El Paso County
Planning and Community Development Department
2880 International Circle,
Suite 110
Colorado Springs, Colorado 80921

Administrative Relief Letter of Intent

Kyle Adrian Kenyon
1010 Tari Dr.
Colorado Springs, Colorado Spring

A1.3 PLOT PLAN

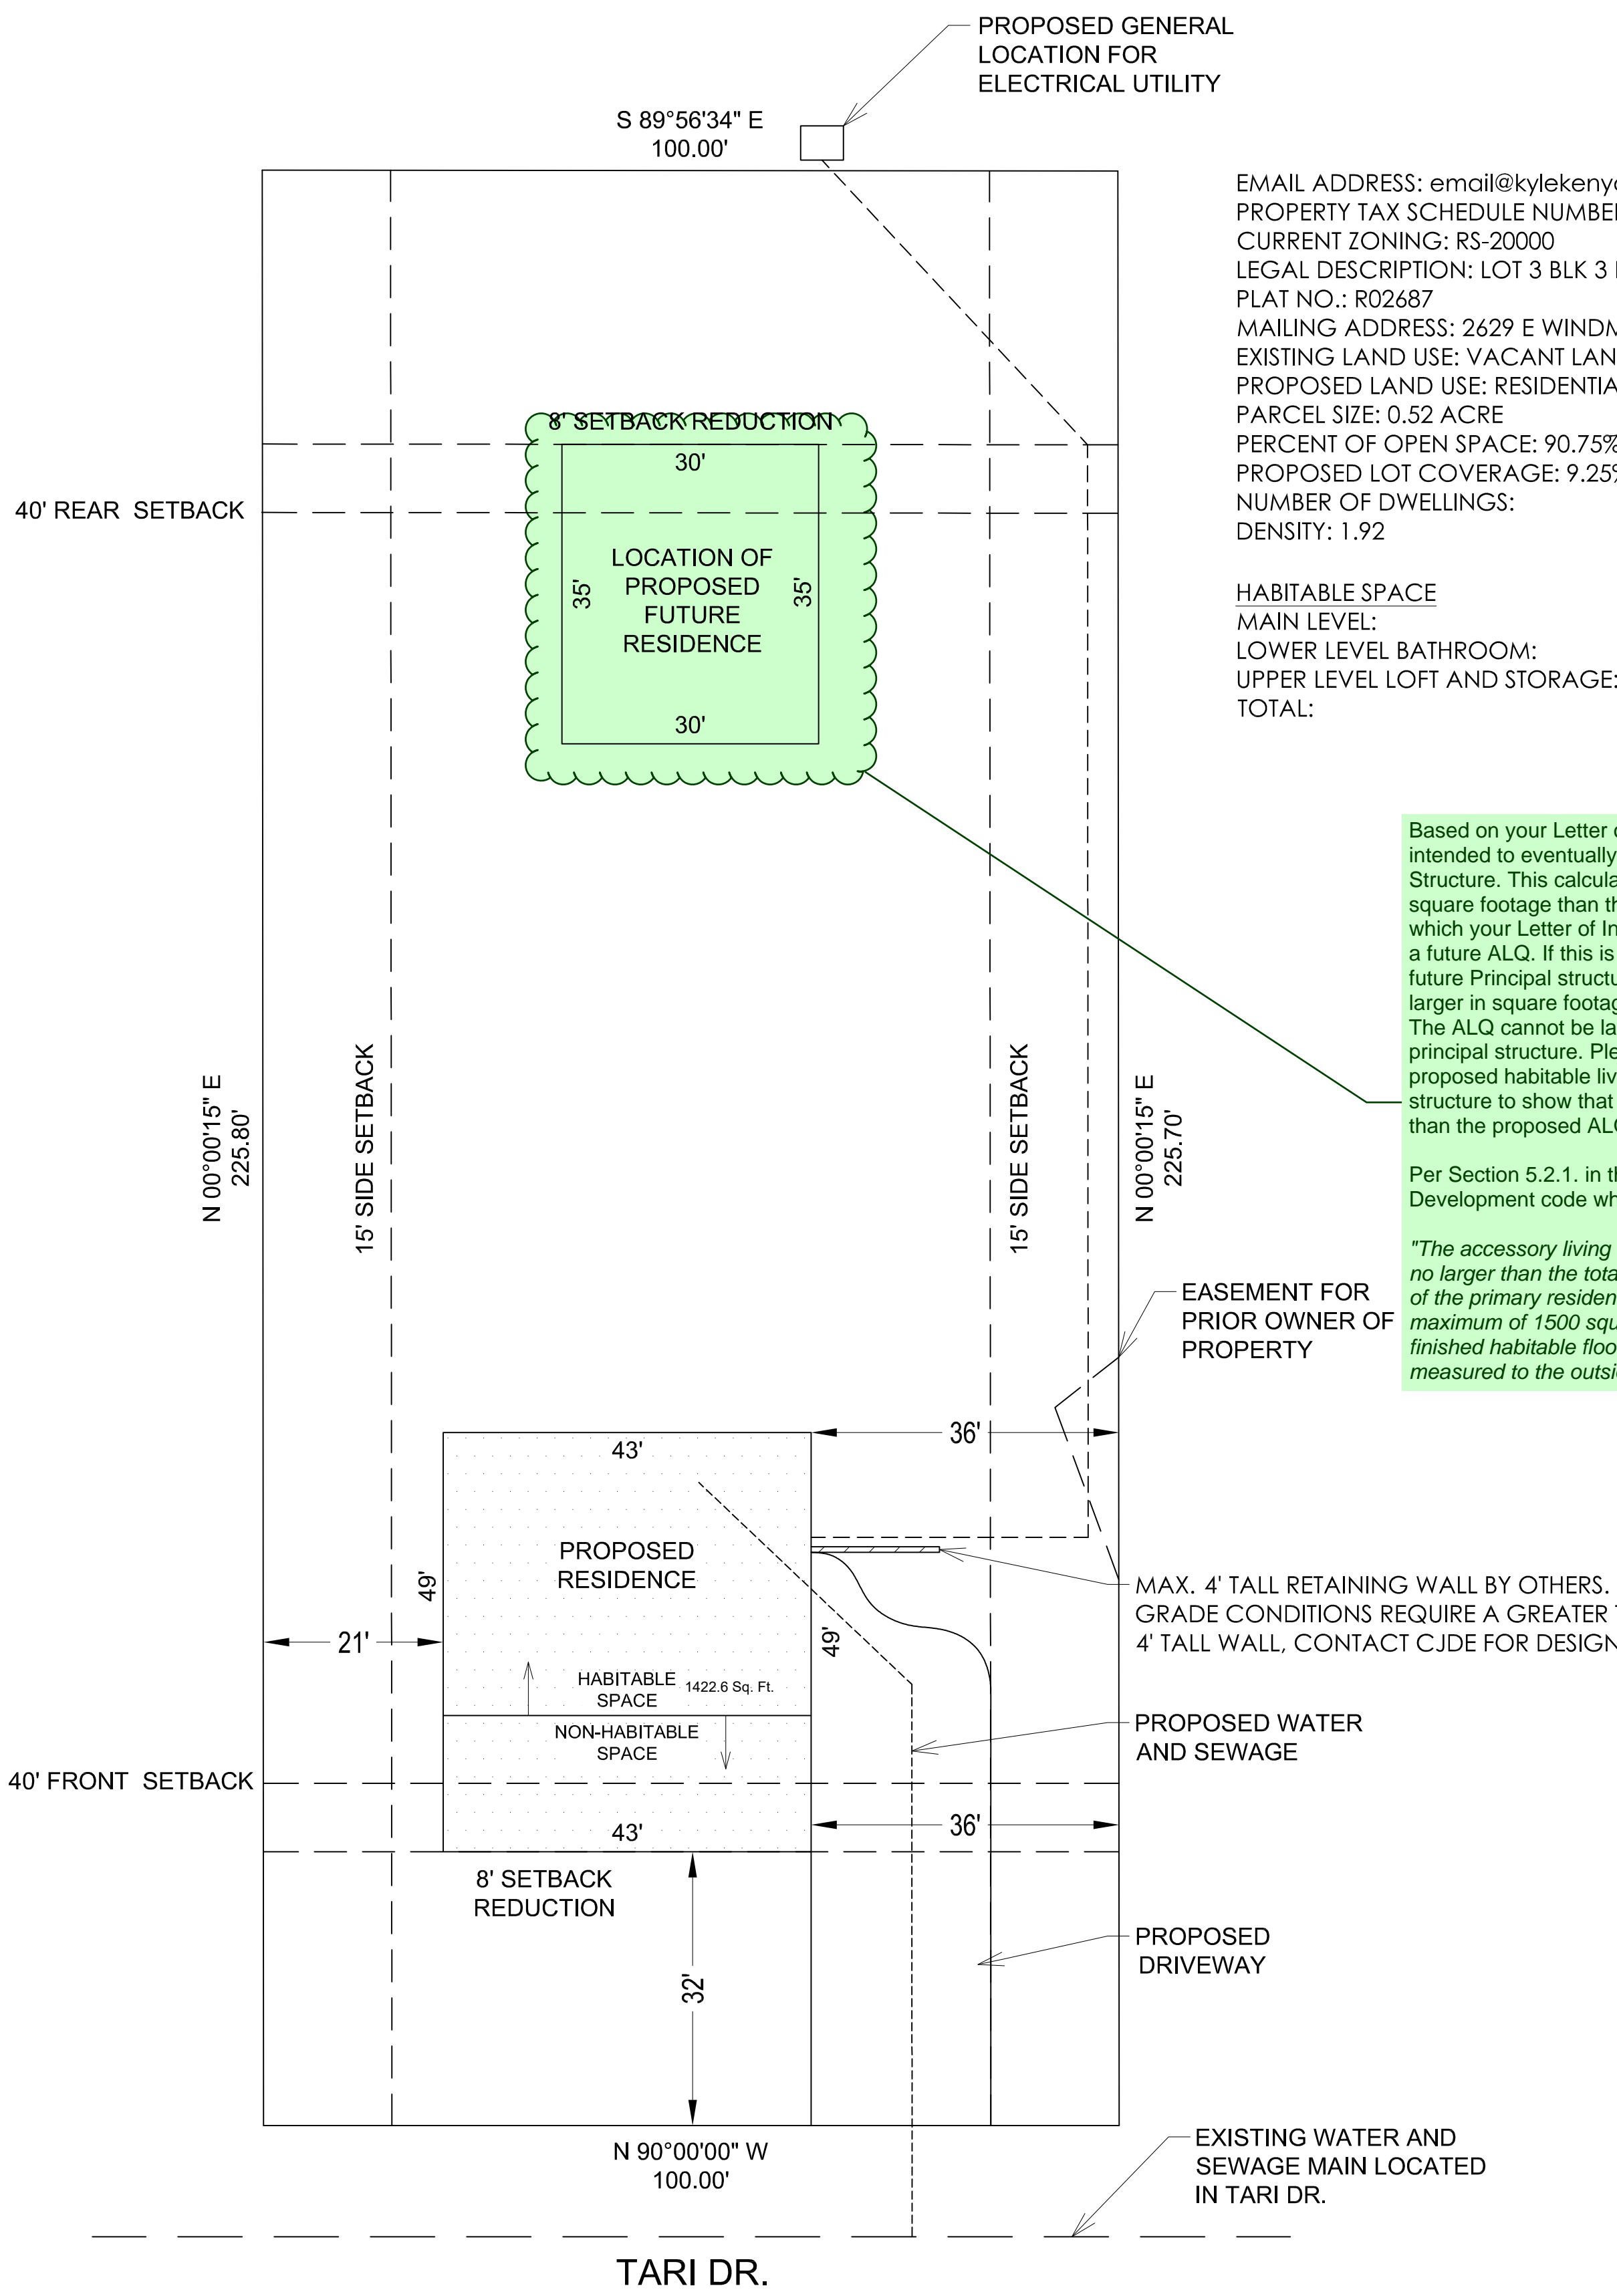
I am writing to the department seeking 20% administrative relief on the front and rear setback requirements for RS-20000 zone lot properties. add discussion about needing relief for the size of the ALQ as noted on the Site Plan.
